**re: Planning Applications Received by Welwyn Hatfield Council**

Application No.	Description and Location	Applicant/Agent
S6/2015/1061/MA	Erection of a private healthcare facility (use Class C2) to include car/cycle parking, boundary treatment, landscaping, lighting and access.  Plot 6000 Hatfield Business Park Hatfield, AL10 9UA	Mr R Moxon Arlington Business Parks GP Ltd Arlington House Arlington Business Park Theale RG7 4SA

**WELWYN HATFIELD ACCESS GROUP'S RESPONSE TO PLANNING APPLICATION S6/2015/1061/MA**

Drawing number:
 1005 NMA 302 B

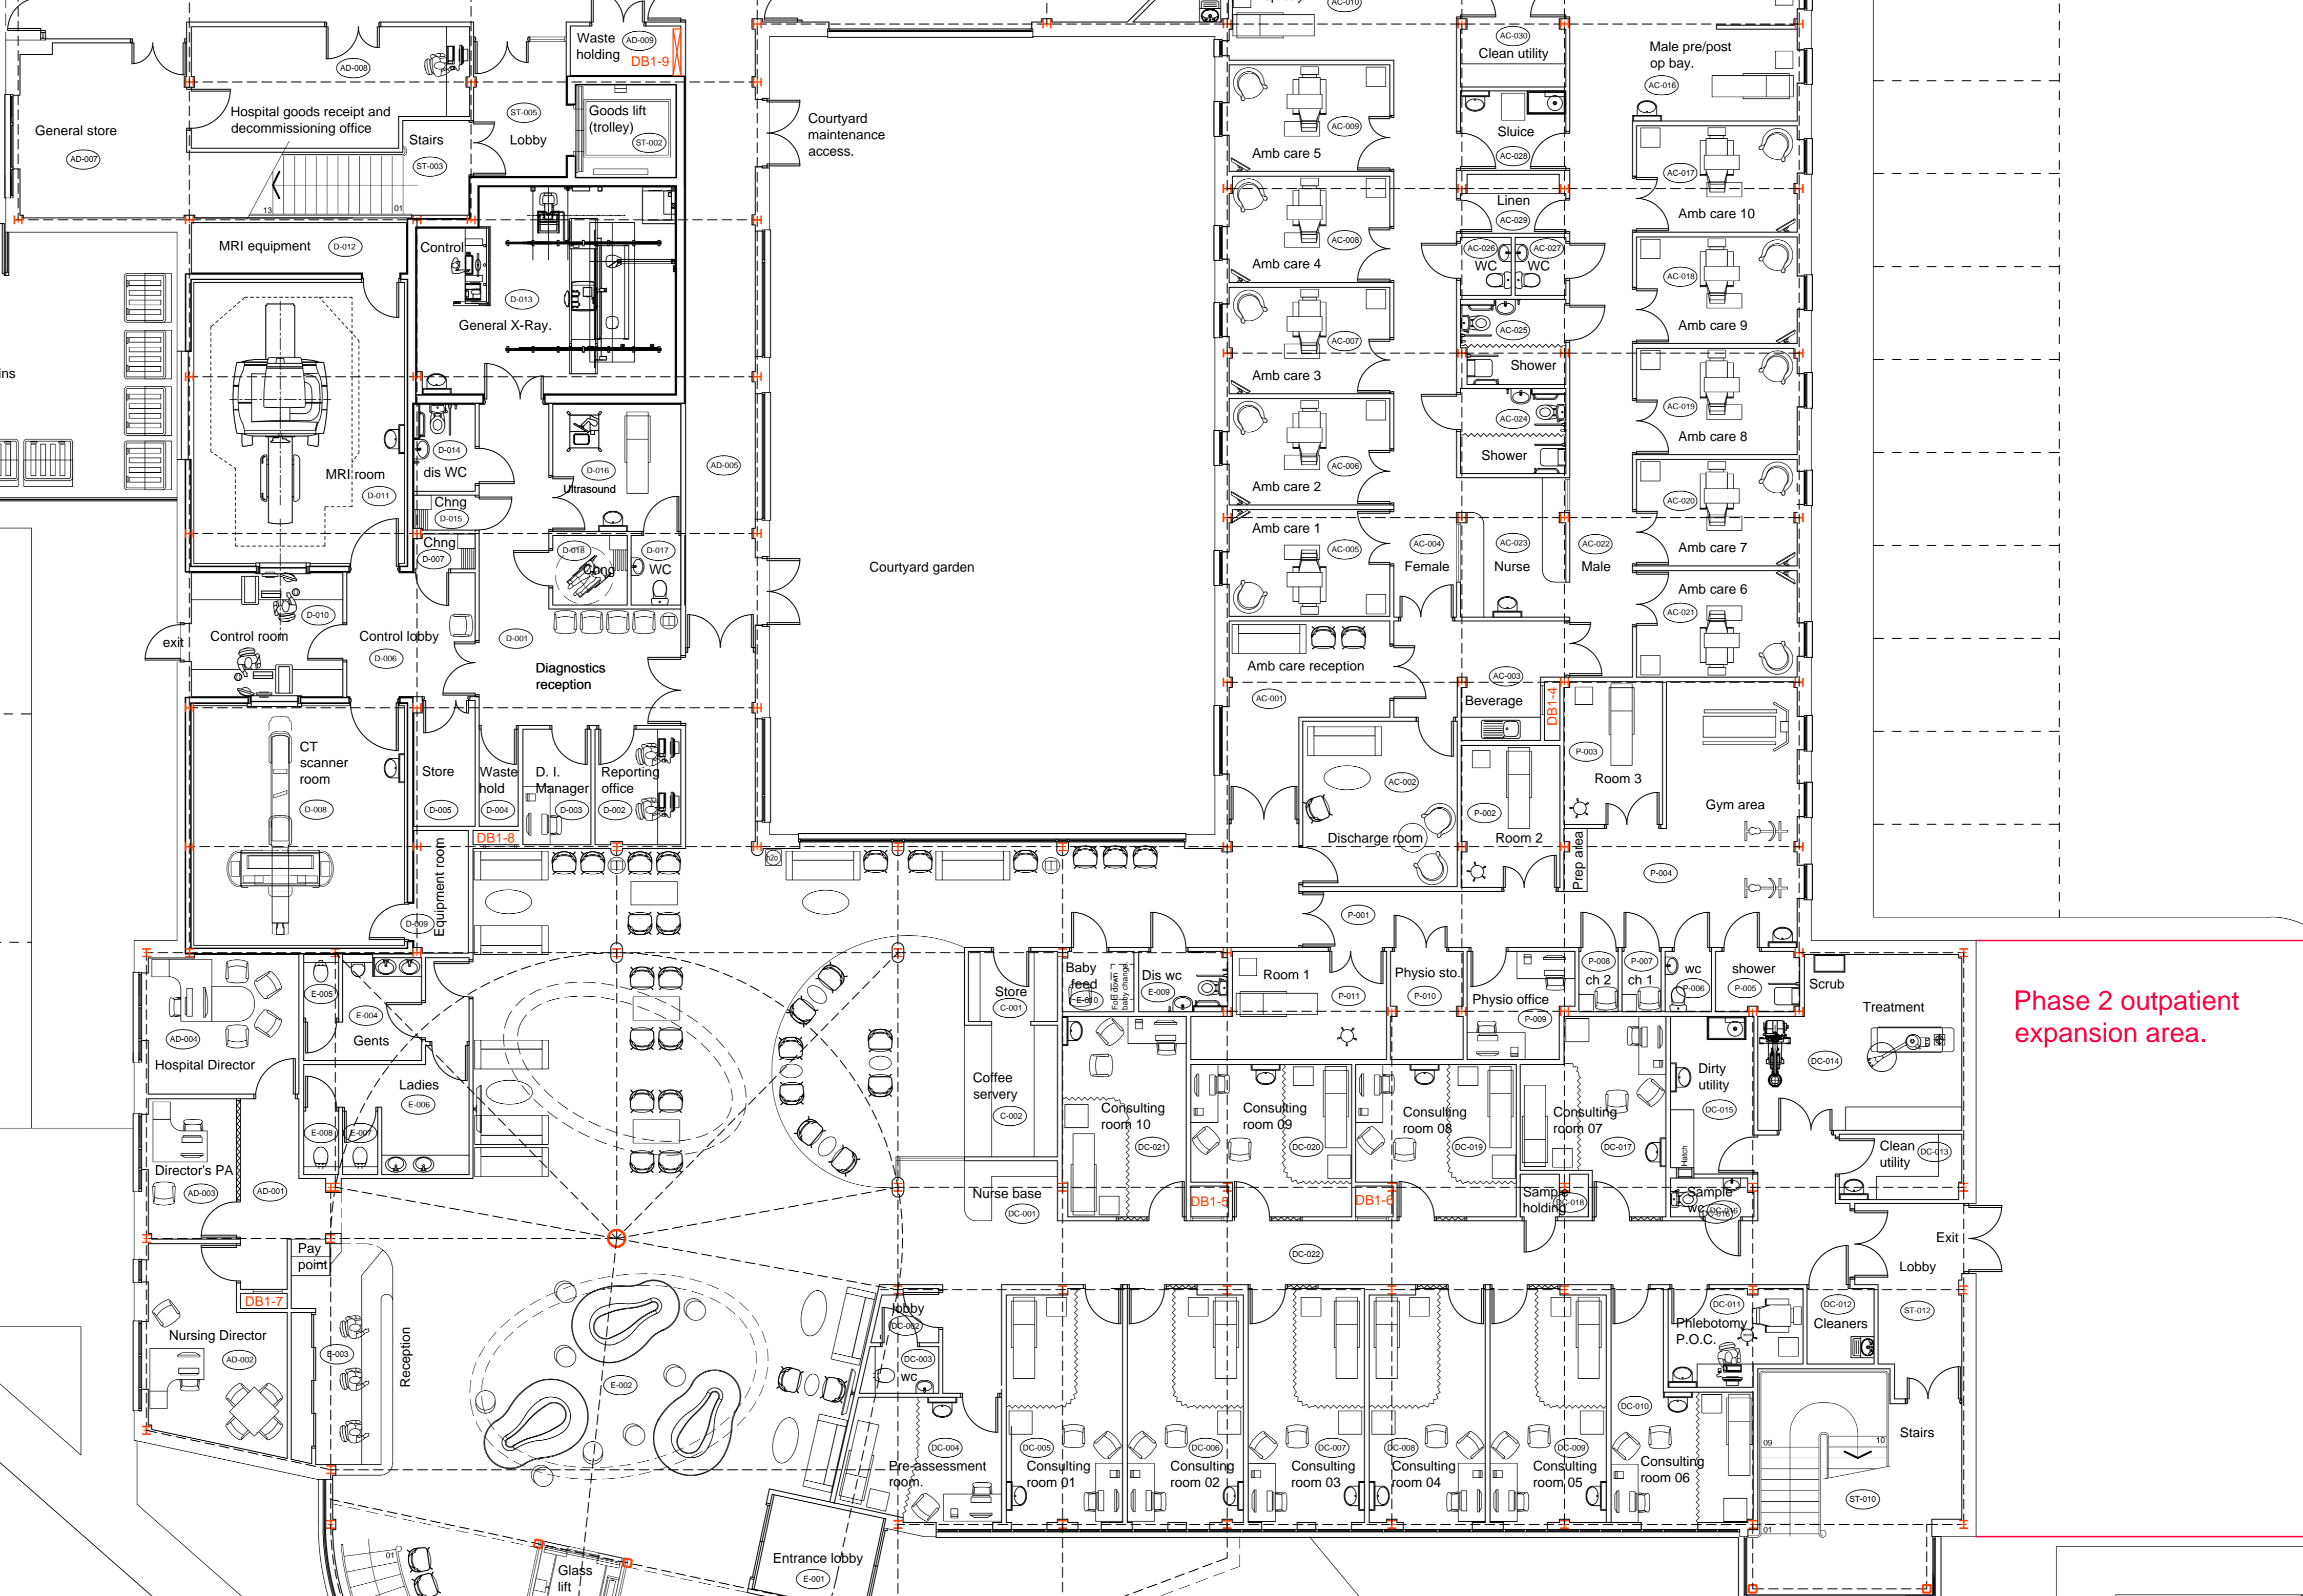
<p>DRAWINGS: PL302 AND PL304</p>	<p>These drawings outline the ground floor plans for both Phases 1 and 2.</p>	<p>Could you please advise the proposed time differential between Phases 1 and 2?</p>
